**WELWYN HATFIELD ACCESS GROUP  
HAZEL GROVE COMMUNITY CENTRE  
HAZEL GROVE  
WELWYN GARDEN CITY  
HERTFORDSHIRE AL7 2DG**

***re: Planning Applications Received by Welwyn Hatfield Council***

<b>Application No.</b>	<b>Description and Location</b>	<b>Applicant/Agent</b>
S6/2013/1469/FP	Erection of single storey side and rear extension and two storey rear and side extensions and provision for additional parking  Oak Cottage Care Ltd Wilkins Green Lane Hatfield AL10 9RT	Mrs P Batchelor 34 Claudian Place St Albans Hertfordshire AL3 4JF

| DRAWING NO.<br>EL/2012/08  | REV. NO.<br>E     |

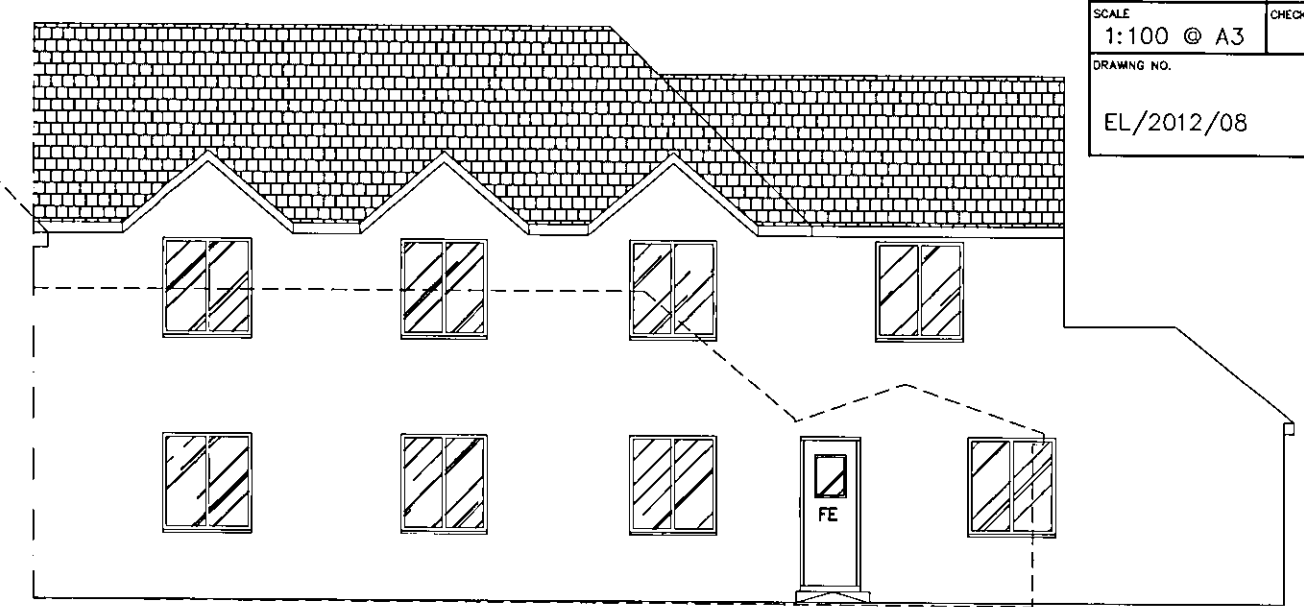
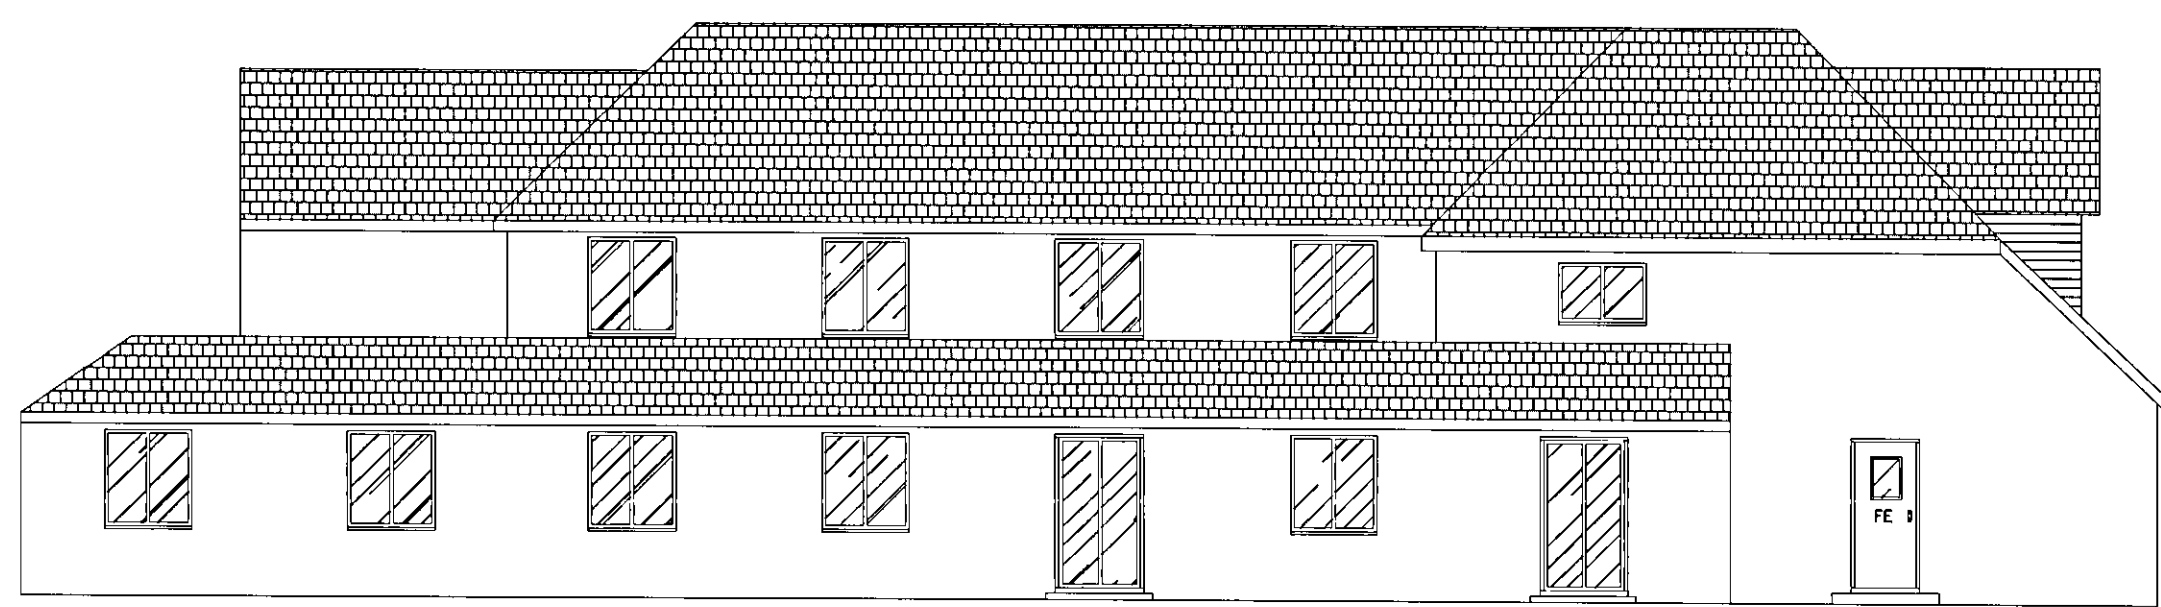
We note the details provided by this drawing showing there is stepped entry at all doors. This is not appropriate for wheelchairs and limited/impaired mobility persons and should in our opinion be changed to level entry especially as some, if not all, may double as fire exits.
